Conservation Area Advisory Committee

Meeting Date : 5th May 2009

App No	Description/Address	Comment	Recommendation/Observation
LU/71/09/	Alterations to frontage and interior to change use of two existing shops to form two new residential units. (Re-submission following LU/7/09/) 7& 9 Norfolk Road Littlehampton	Comment	~~New door~~ Front door should be recessed + 4-6 wooden panels, should be painted timber. (Top 2 which could be glazed New window should similarly be recessed with stone to match existing.
R/61/09/	Change of use from Class C2 (residential institutional) use and alterations to form 10 bungalows (with Class C3 use) together with the erection of a car-barn for six vehicles, parking, open space and new entrance gates (Amendment to previously approved R/163/08) West Preston Manor Bungalows Pigeonhouse Lane Rustington	No comment-	Improvements such as this are welcomed

West Elevation to Norfolk Road

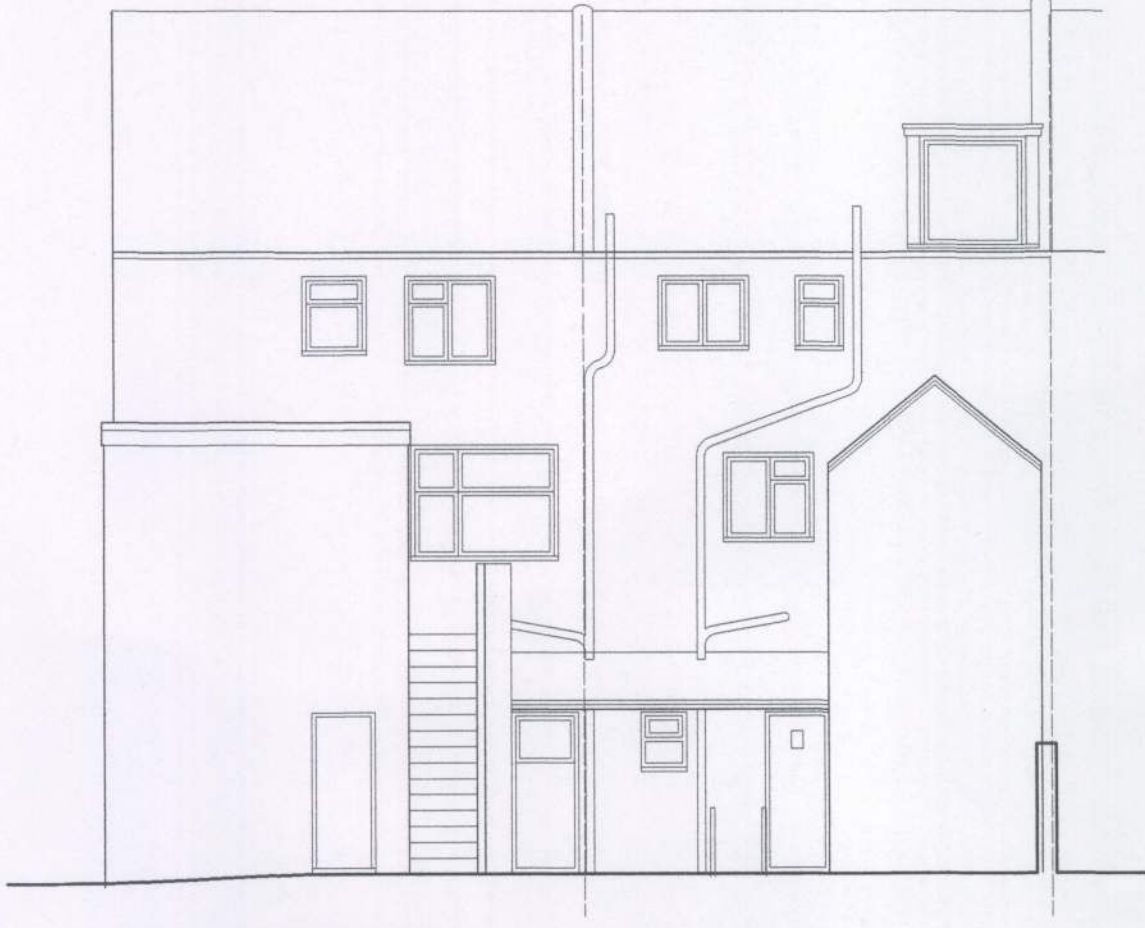
to match existing properties
